Re: PA22-042 – Sunnyside Village Co-Housing – Technical Review 2
3121 66th Ave NE – APN: 29050300402100

After preliminary review of the above referenced proposal, the Planning Division has the following comment(s):

A000

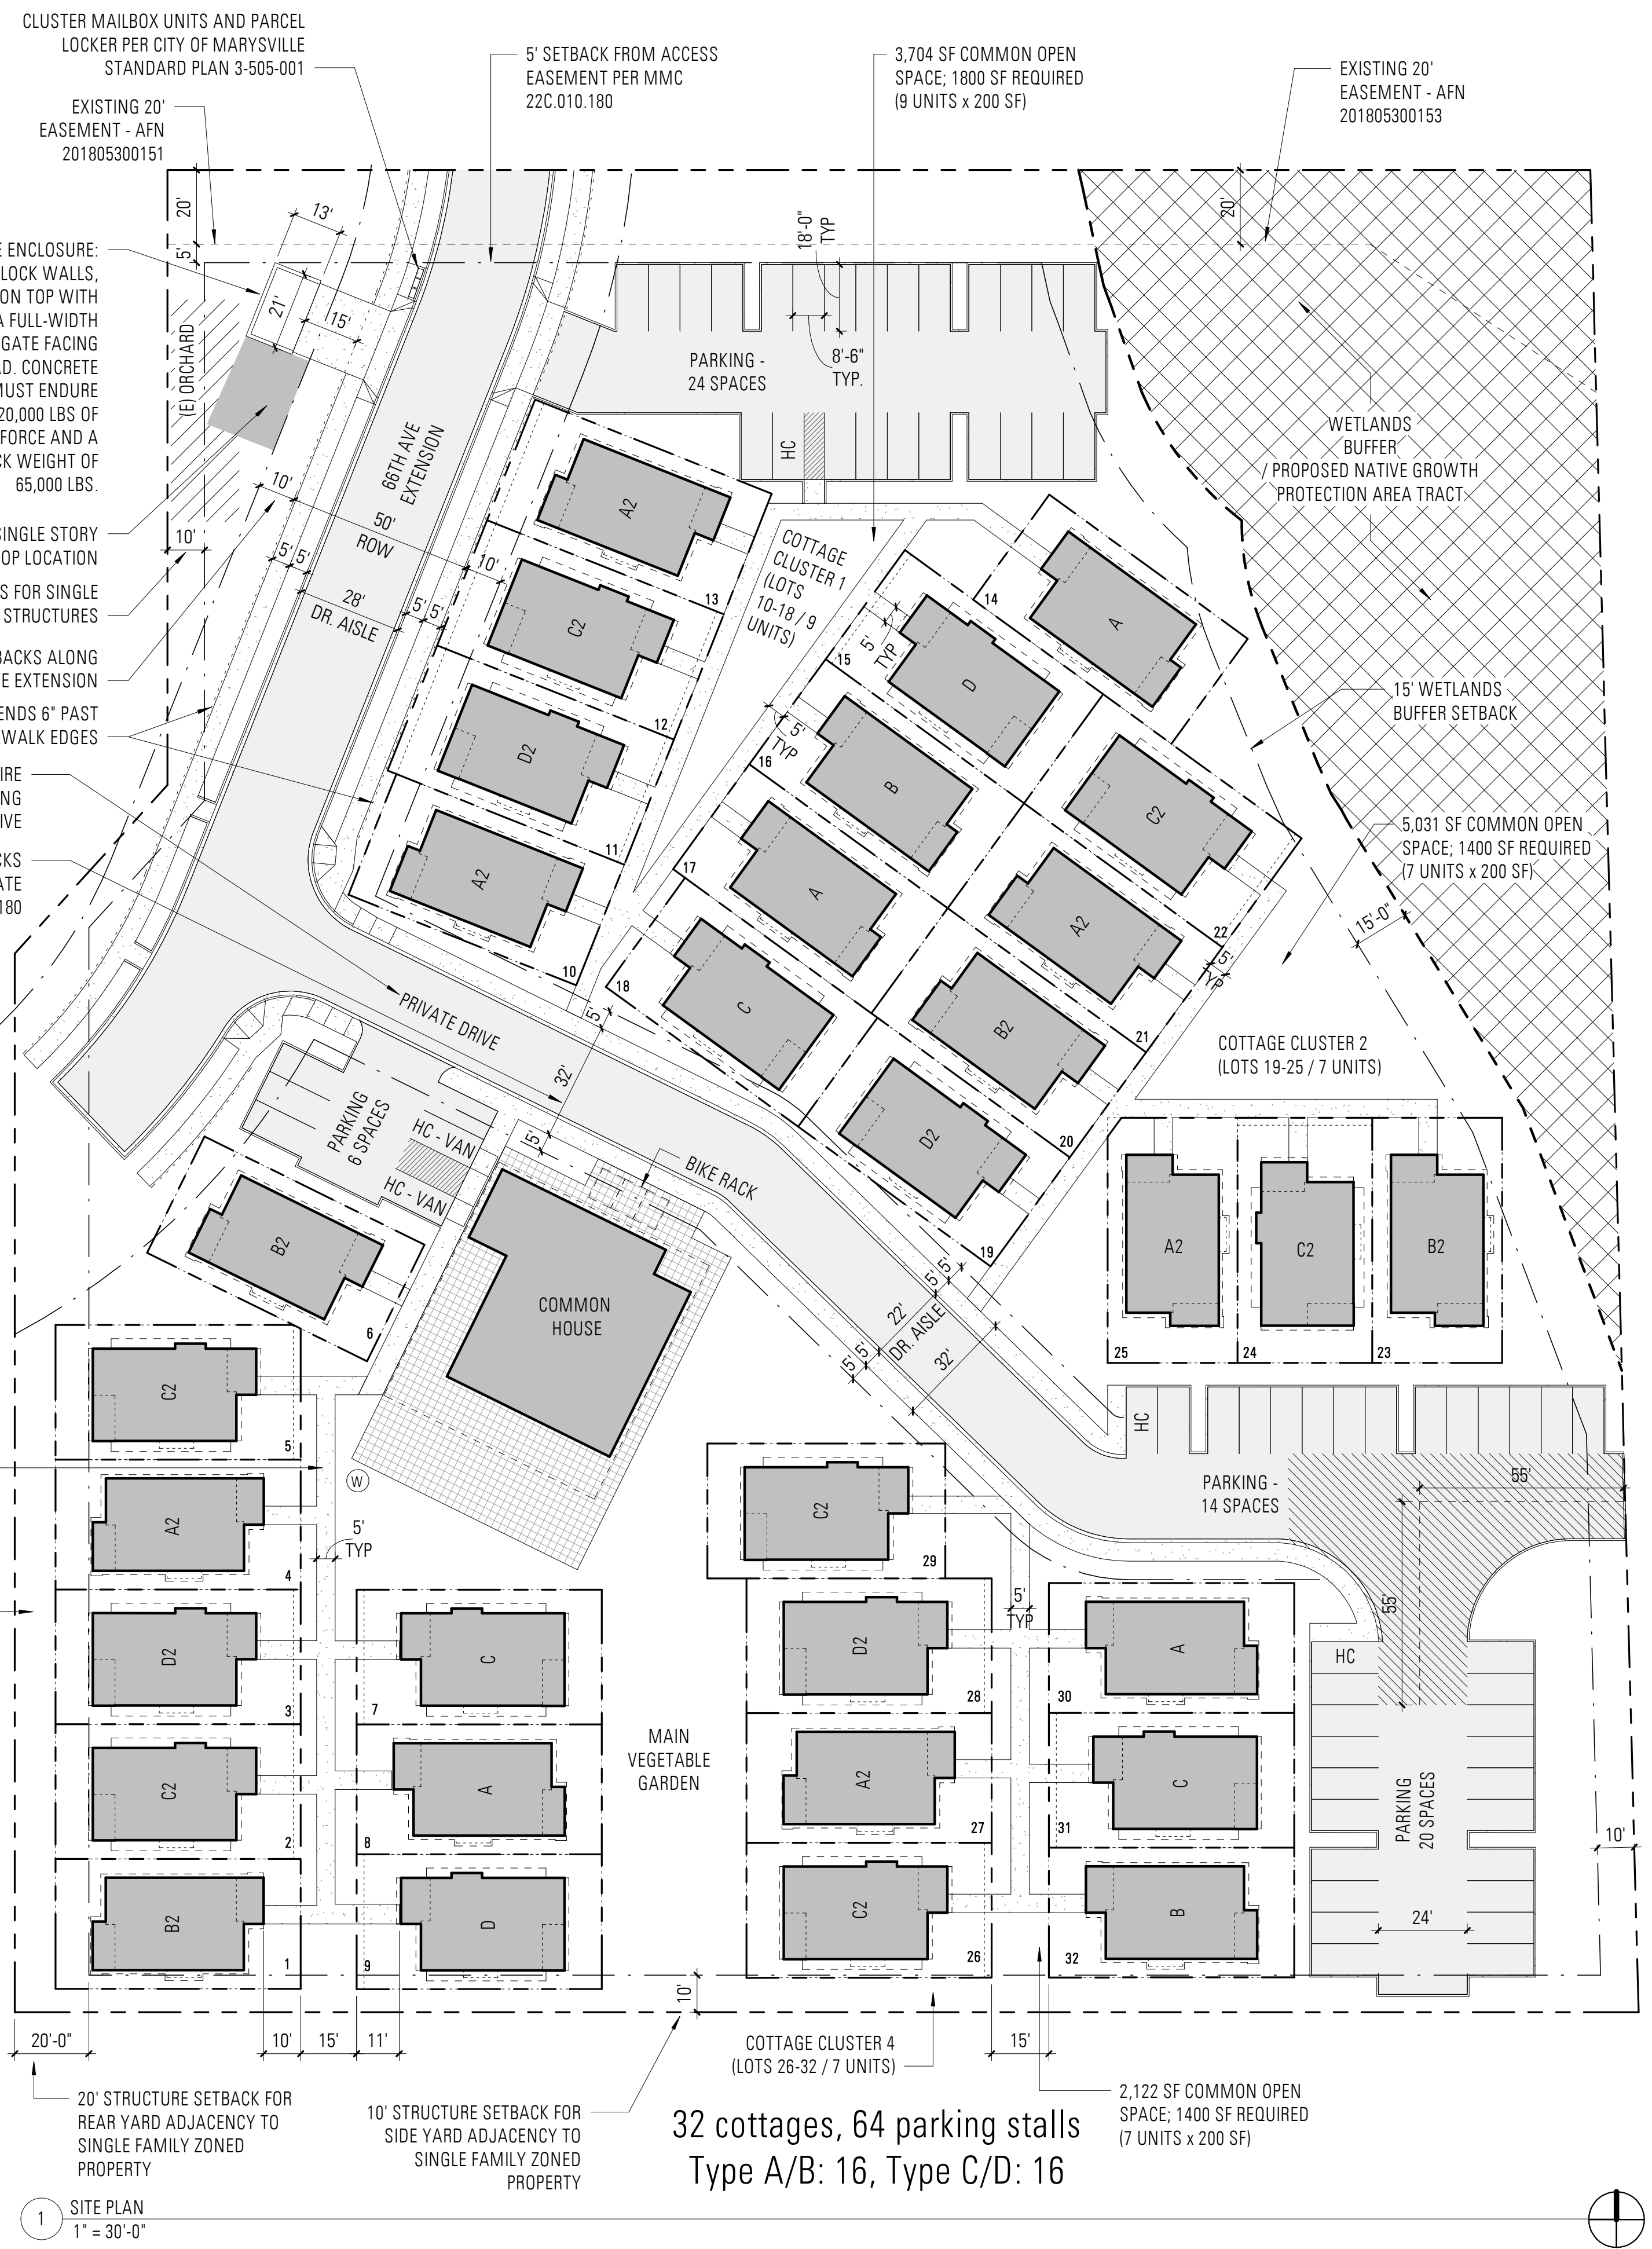
1. Revise the NPGA tract to be delineated via solid lines (rather than dashed) as this area would be a completely separate tract/lot. Clearly label accordingly NPGA tract accordingly.

1 - Preliminary site plan sheet A000 has been updated accordingly
